# CITY OF ALBUQUERQUE

August 22, 2019

RE: **Swim Labs**  
**8110 Holly Ave NE**  
**Grading Plan Stamp Date: 8/13/19**  
**Drainage Report Stamp Date: 8/13/19**  
**Hydrology File: C20D082**

Designed: <i>CP/DMG</i>	Drawn: <i>CP</i>	Checked: <i>DMG</i>	Sheet <i>C1</i>
Scale: <i>1" = 20'</i>	Date: <i>7/24/2019</i>	Job: <i>A19003</i>

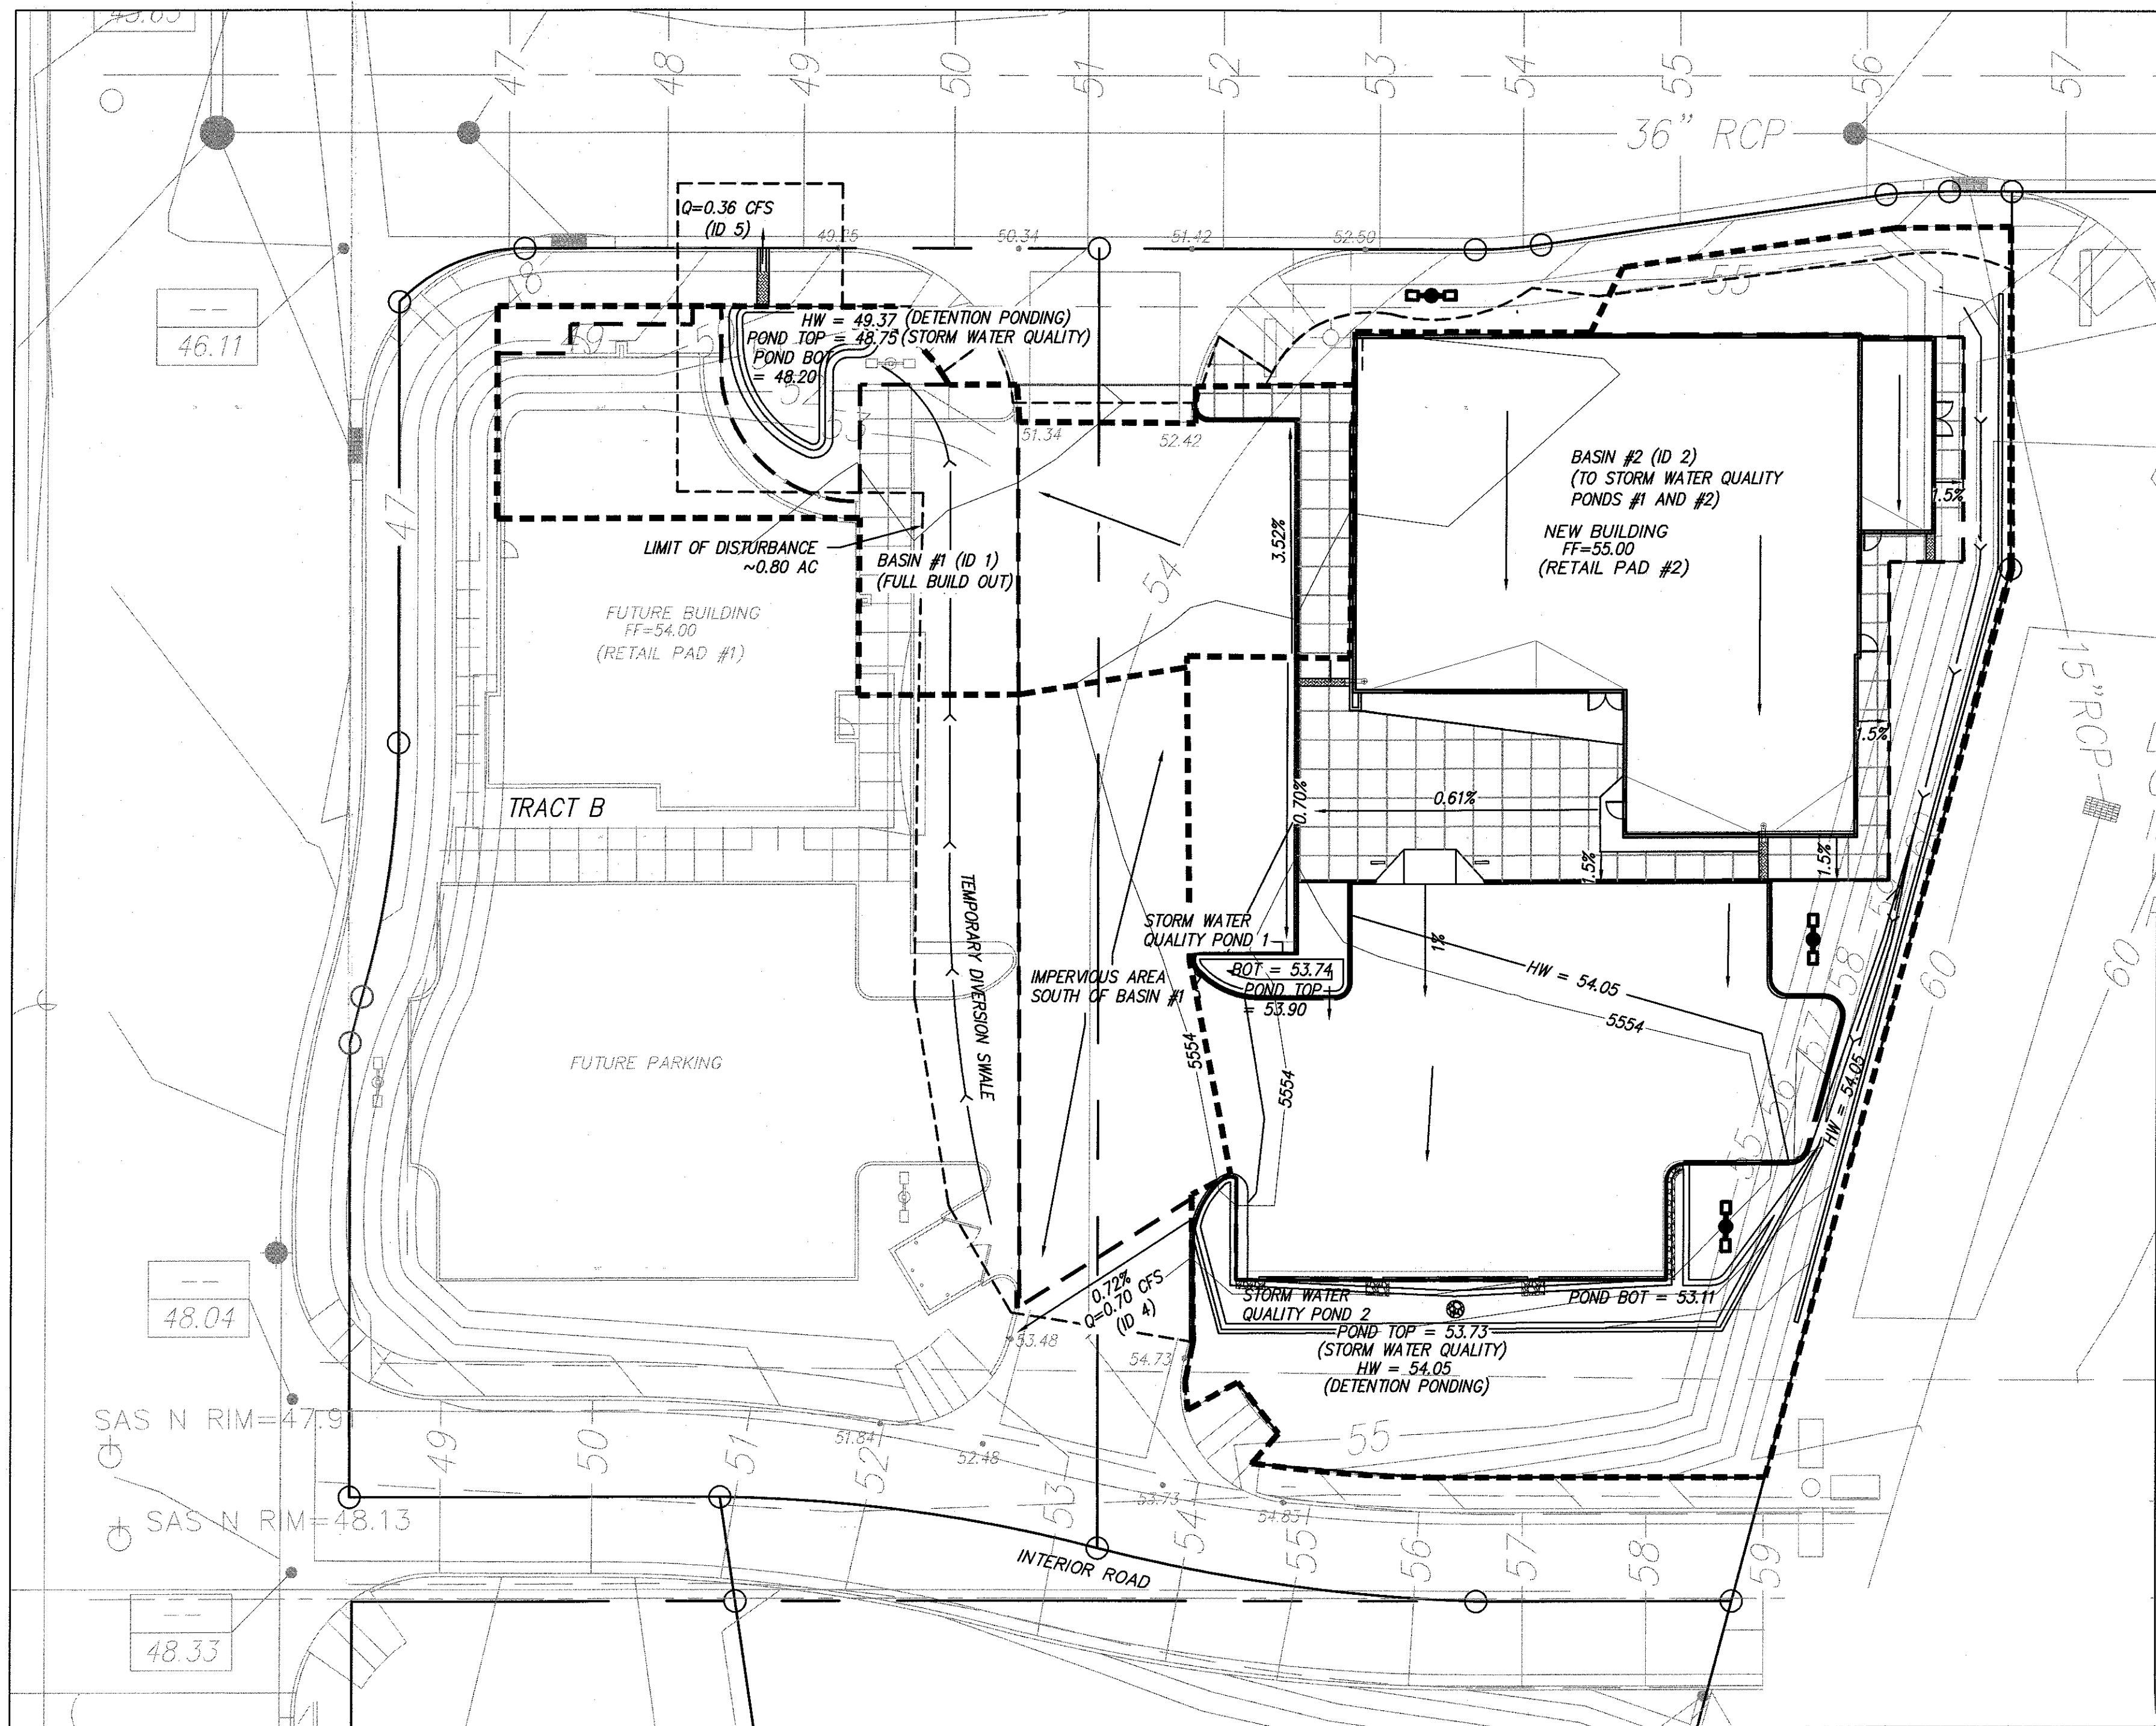
1. Provide written and signed permission from the owner of Tract B for the grading, paving and pond construction on their property. Unfortunately the cross-lot drainage easement does not grant the right to perform work on their property, only to discharge to it. (A permanent pond covenant will also be needed from this owner prior to CO; you may want to get it now). Permissive discharges from the two sites need to be coordinated and included in the agreement as well (1.86cfs max combined).

2. Rainfall amounts need to be input as: 0.0, 1.82, 2.45, 2.86, per the Atlas 14 printout and the AHYMO user manual. Rainfall Type needs to be 2, for a 24-hr storm. You cannot just reduce the rainfall for the 100-yr storm; the pond discharge tables need to include the dead storage for the SWQ volume so the entire 100-yr storm may be modeled and routed.

3. For Information. Hydrology recommends against using the parking lot as dead storage for ponding water (Pond 2).
4. As a reminder, if the project total area of disturbance (including the staging area and any work within the adjacent Right-of-Way) is 1 acre or more, then an Erosion and Sediment Control (ESC) Plan and Owner's certified Notice of Intent (NOI) is required to be submitted to the Stormwater Quality Engineer (Curtis Cherne, PE, ccherne@cabq.gov, 924-3420) 14 days prior to any earth disturbance.
